The Great Grid Upgrade

Bramford to Twinstead Reinforcemen

Document 8.3.9: Applicant's Response to Issue Specific Hearing 1
Action Points

Final Issue A
September 2023

DEDHAM VALE EAST SEALING END COMPOUND:
 PLAN VIEW
 SCALE 1:200

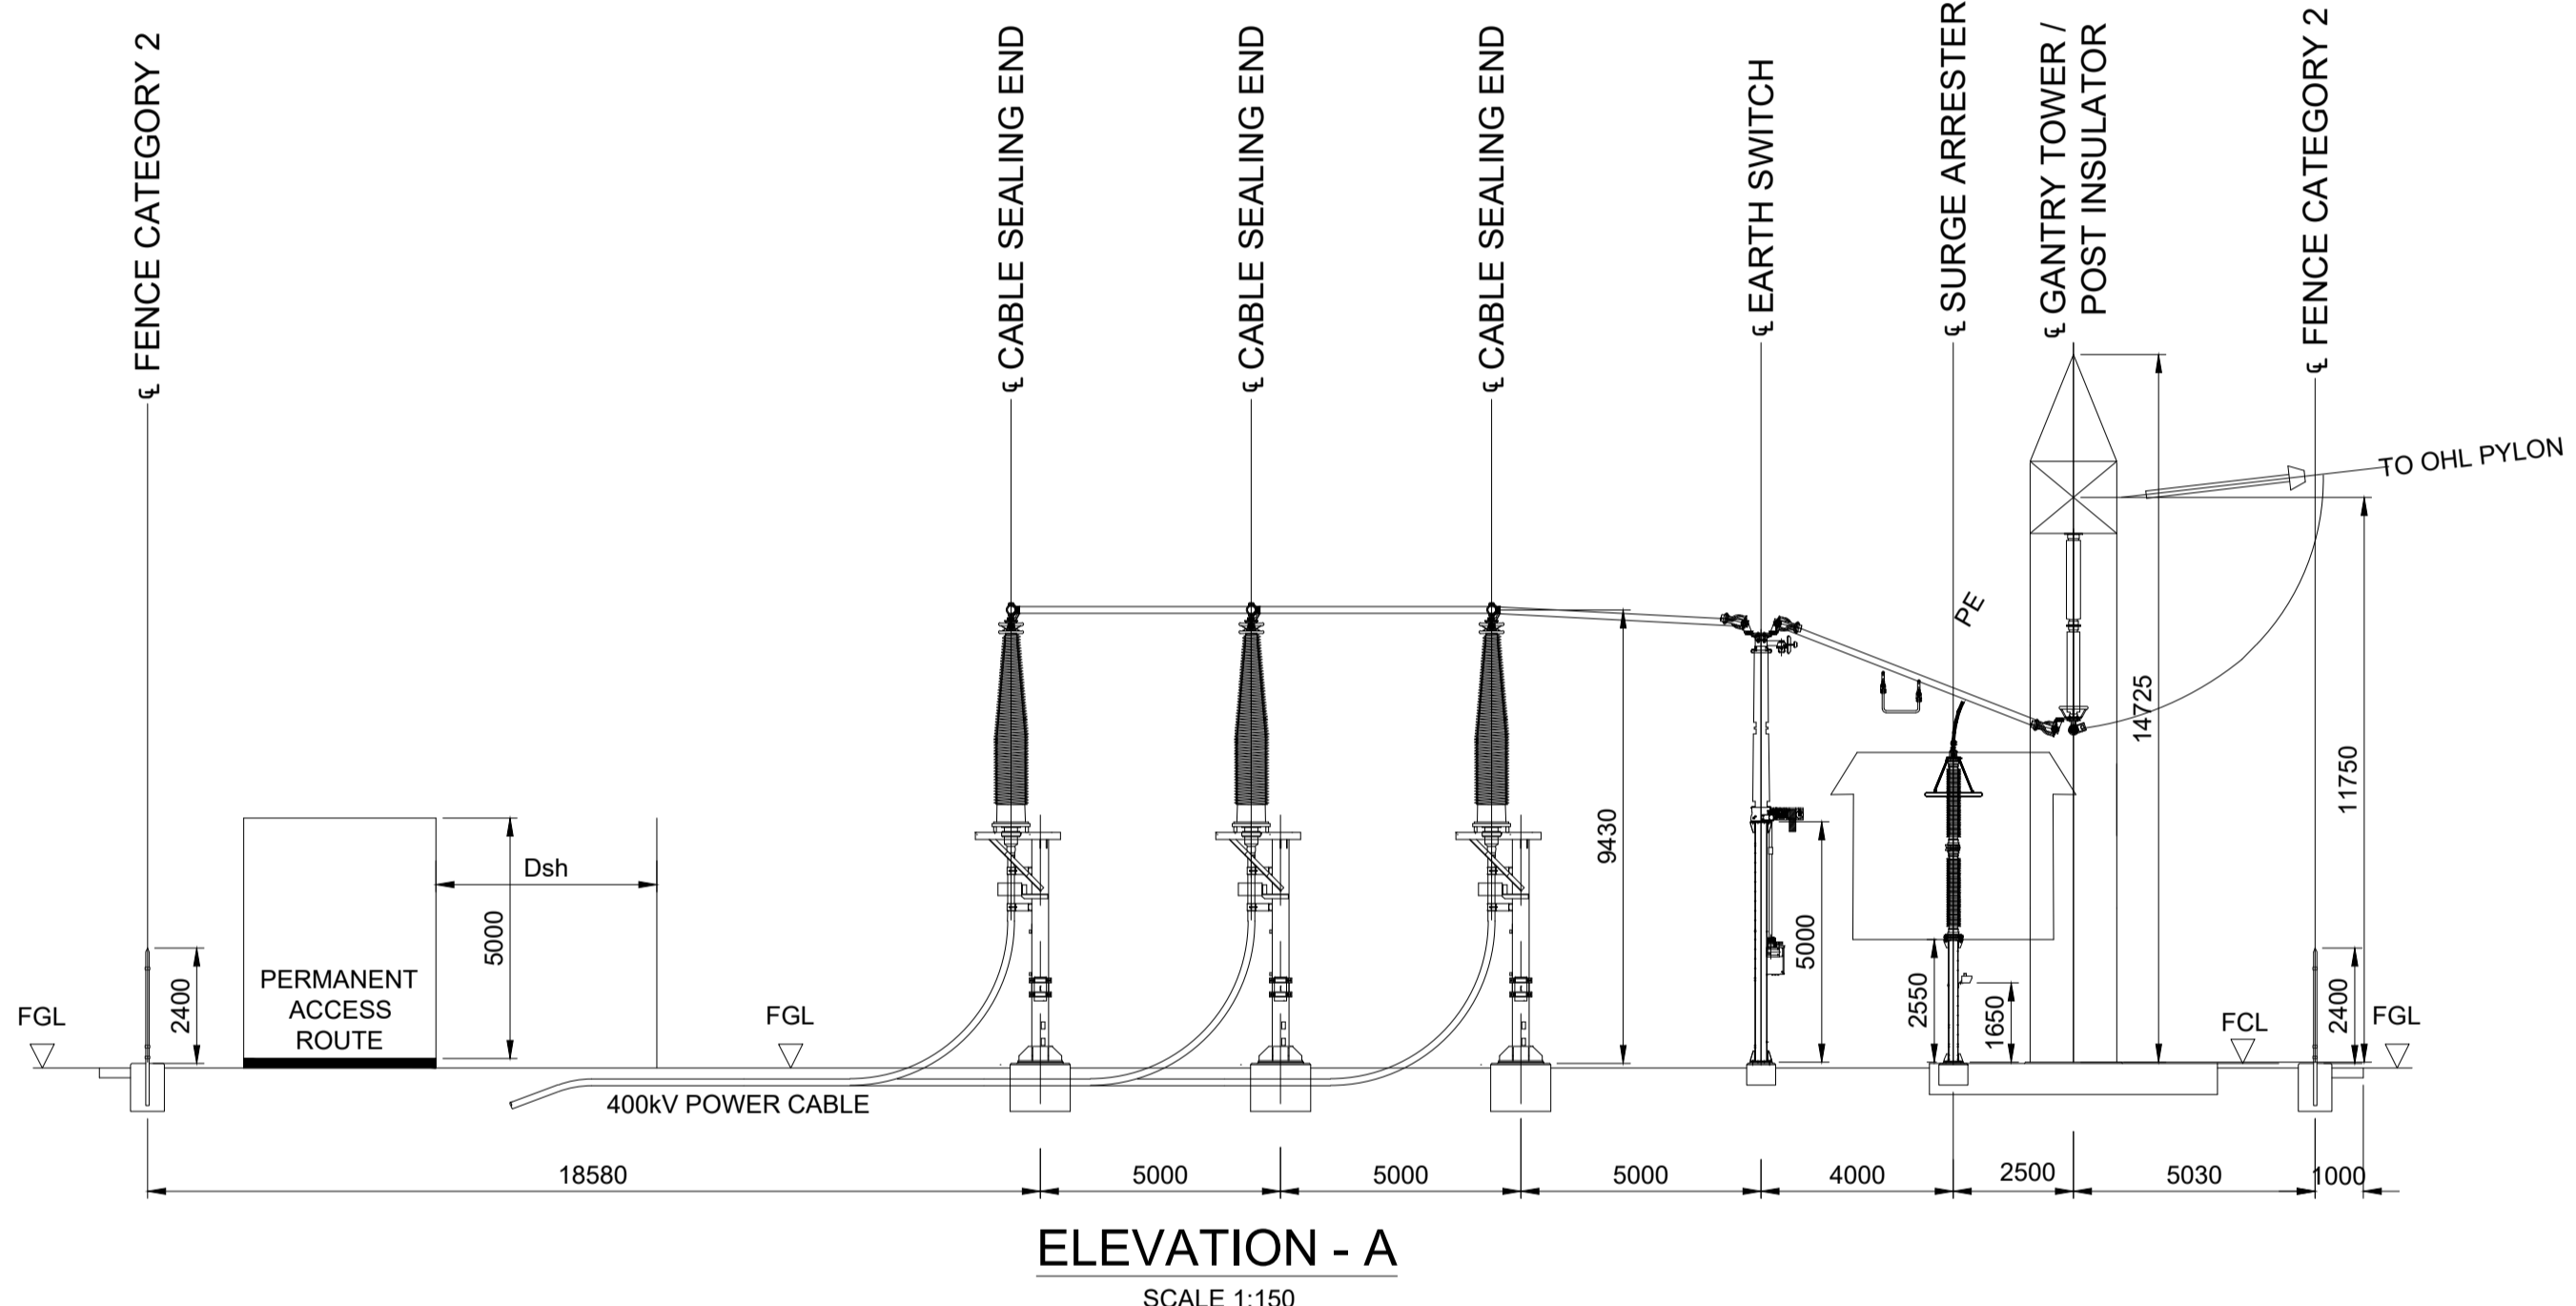
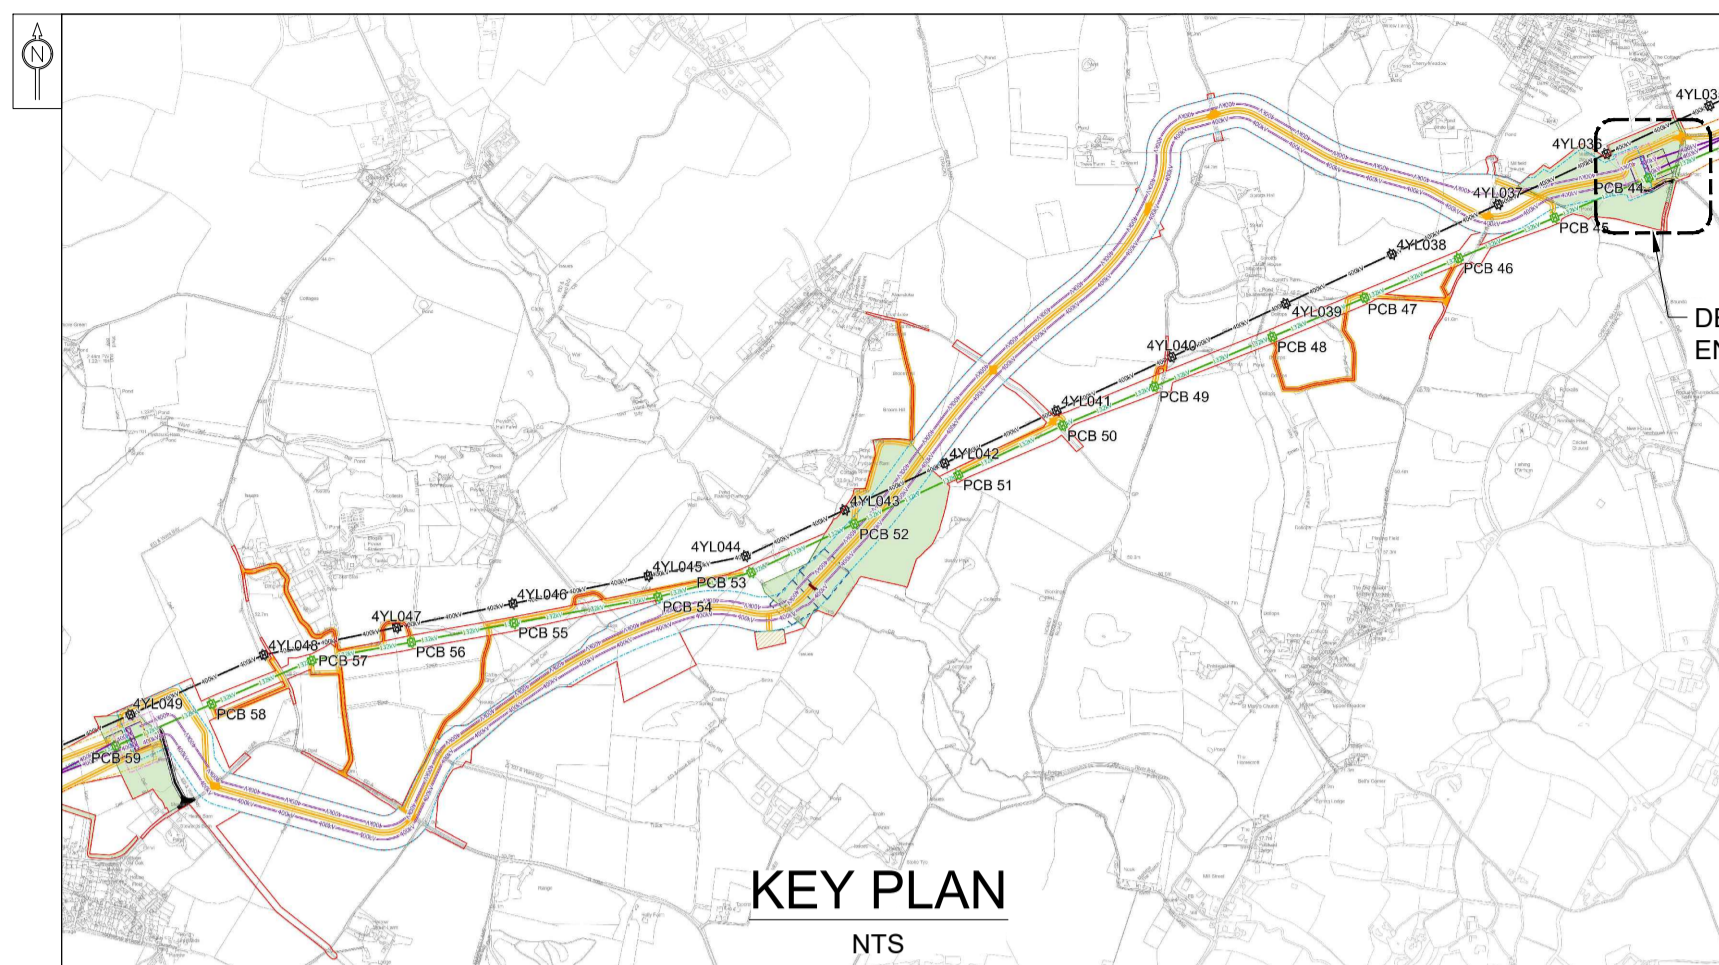
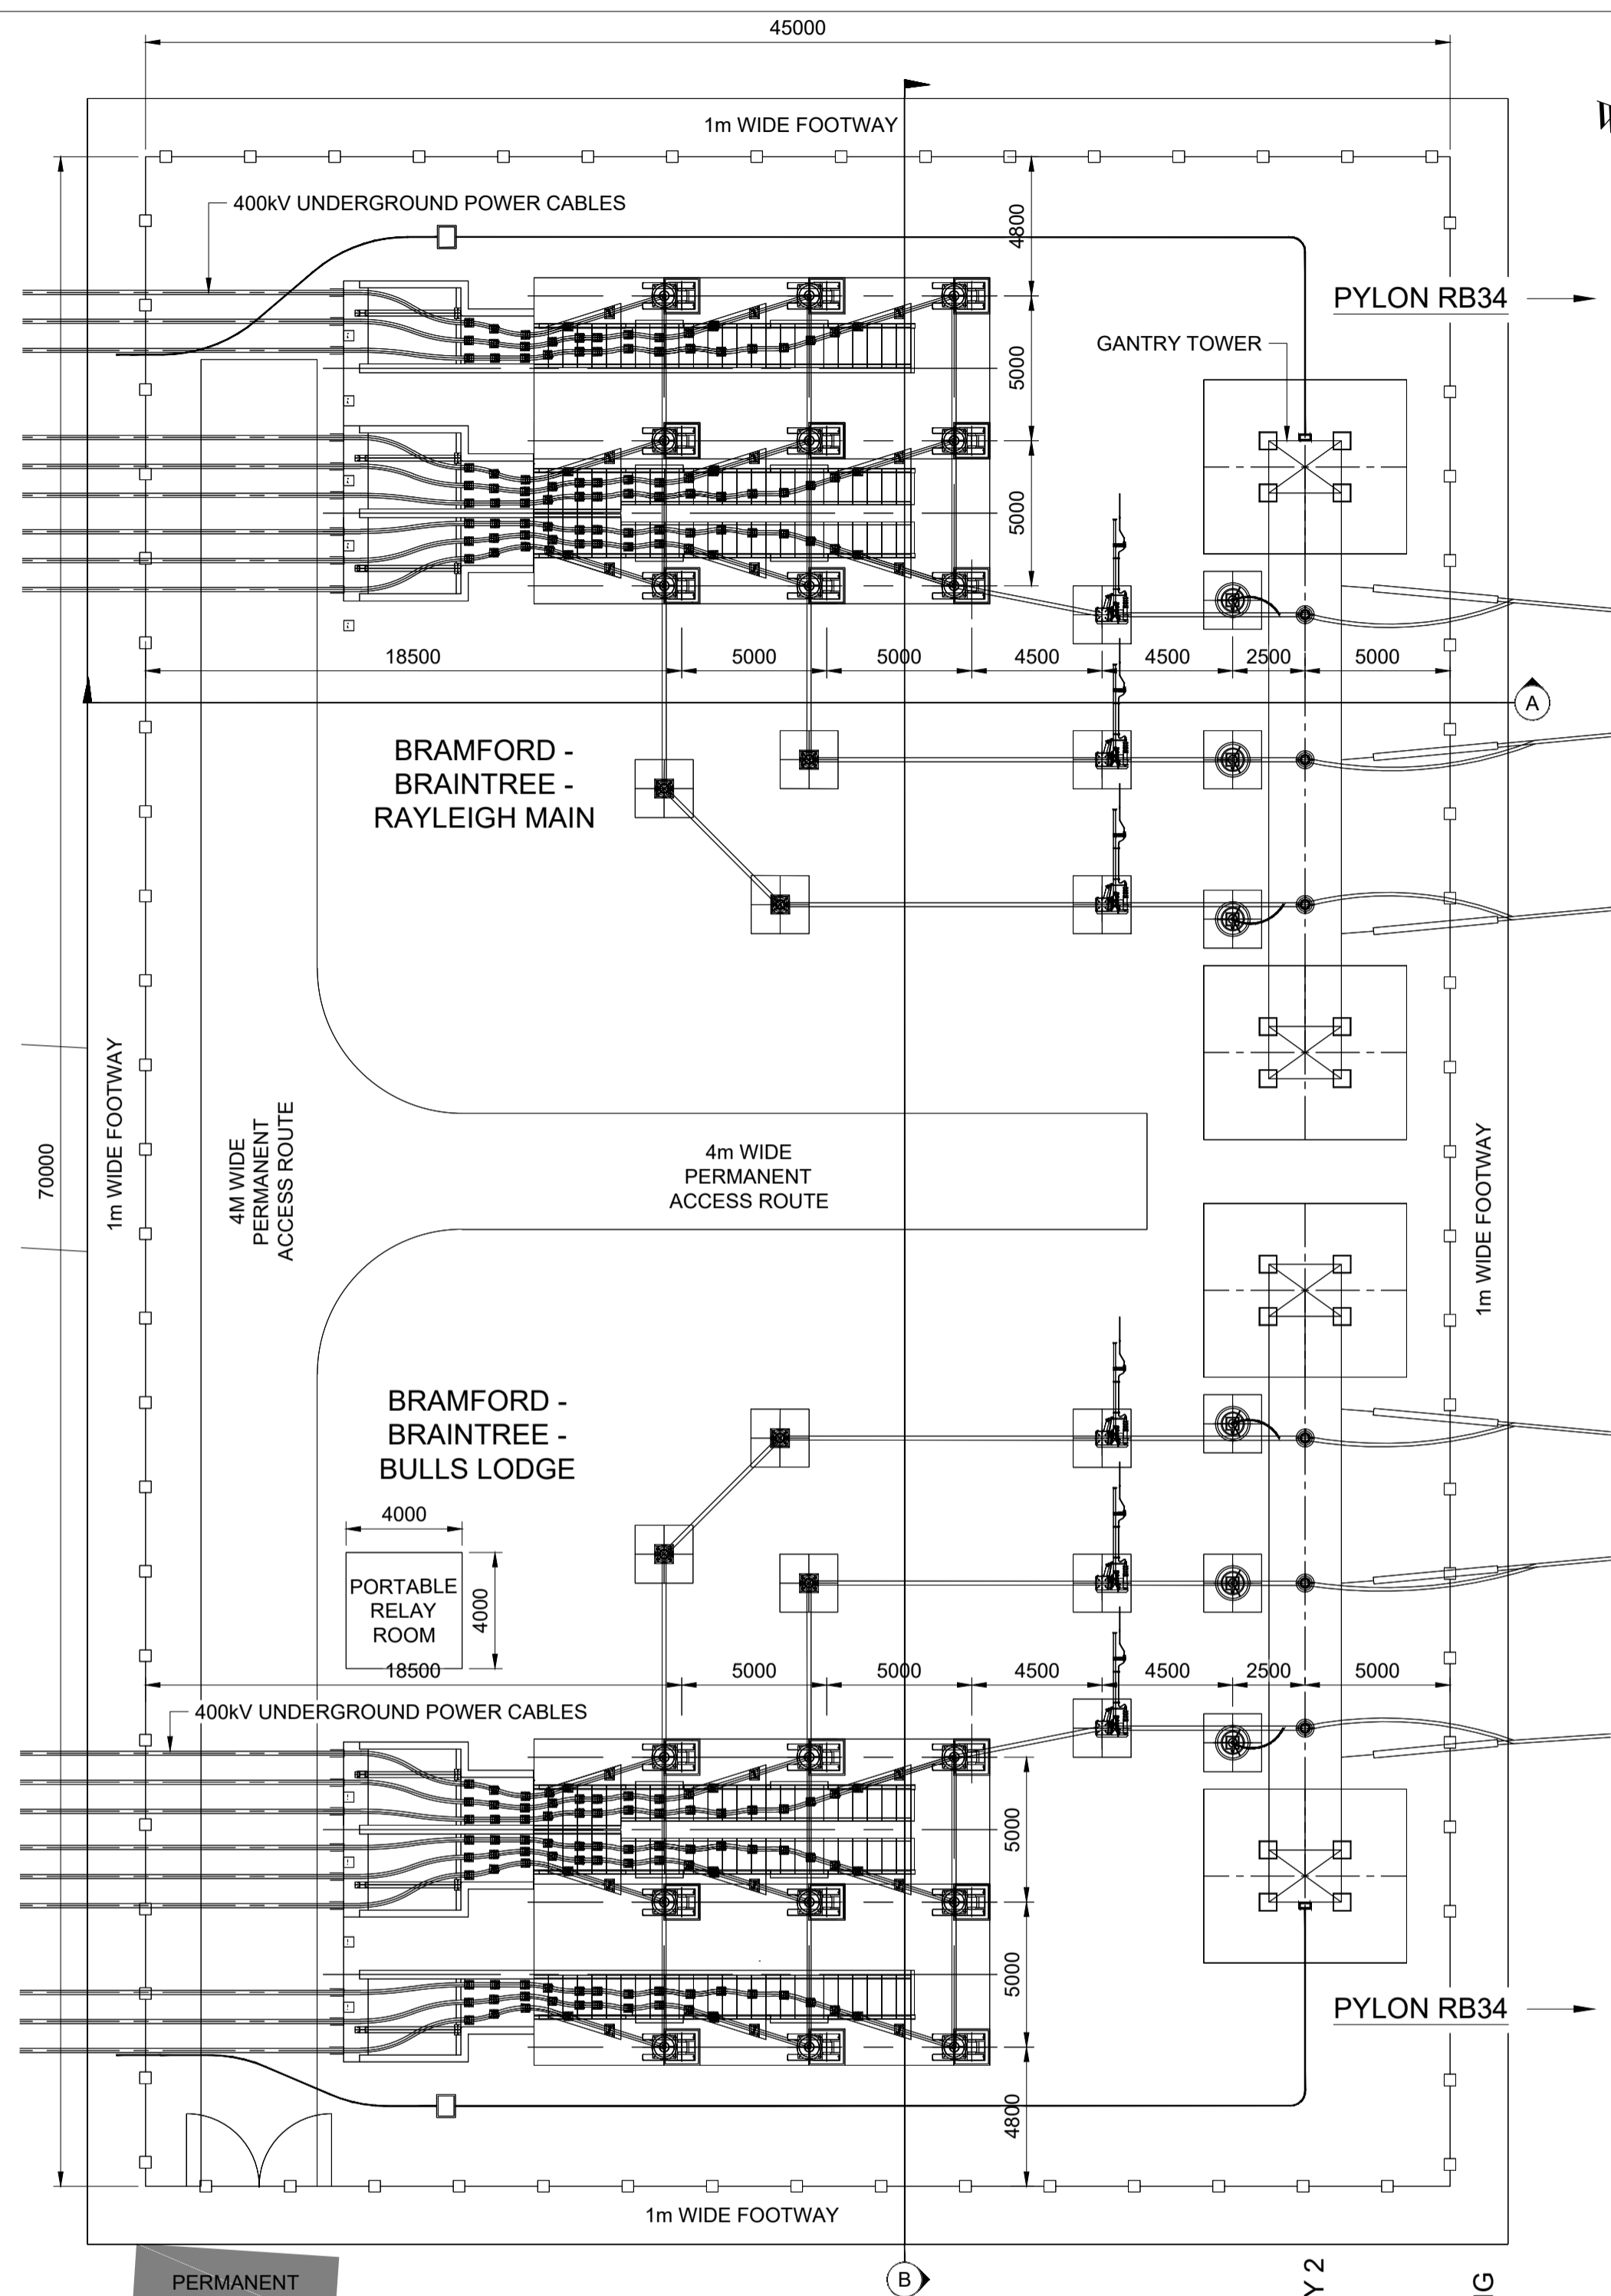
documents.	However, it is noted that the Explanatory Memorandum [APP-035] states (at paragraph 4.1.21) that 'Work Number 7 (shown on Sheets 21, 27 and 28 of the Work Plans) is concerned with the removal of approximately 2.5 kilometres of existing overhead electricity transmission line (Route 4YLA) between the Twinstead Tee and a point to the southwest of Alphamstone (indicated as 4YLA007 on Sheet 28 of the Work Plans).'	
		Essentially, the additional 0.5km (approximate) stated length of 400kV overhead line relates to the length of 400kV overhead line south of the Stour Valley West CSE compound, which whilst this 0.5km (approximate) length is being removed; it is being removed to be realigned in this section.	
		This realignment of the existing 400kV overhead line (as opposed to the in-isolation removal of the overhead line) is described in Work Number 6 of the draft DCO [APP-034] and shown on Sheets 27 and 28 of the Works Plans [APP-010].

The 'non-linear works' (those which are not the linear overhead line nor the linear underground cable) are listed in principal at article 5 (Limits of deviation) of the draft DCO [APP-034] at article 5(3) being the 'other permanent above ground structures, erections and apparatus, including substations and cable sealing end compounds'. Article 5(3)(a) refers to 'any applicable non-linear limits of deviation shown on the Works Plans'.	
		The Applicant, therefore, is the view that the works are properly controlled by the Work Plans and associated draft DCO [APP-034] article 5 in respect of the LoD.	
		To assist the reader, the General Arrangement Plans [APP-018] at Sheet 12 contain a label to this area (pointing to the black lined box which the legend confirms is a 'cable sealing end compound') stating 'Refer to drawing: 2.11.5 Design and Layout Plans: Dedham Vale East Cable Sealing End Compound'.
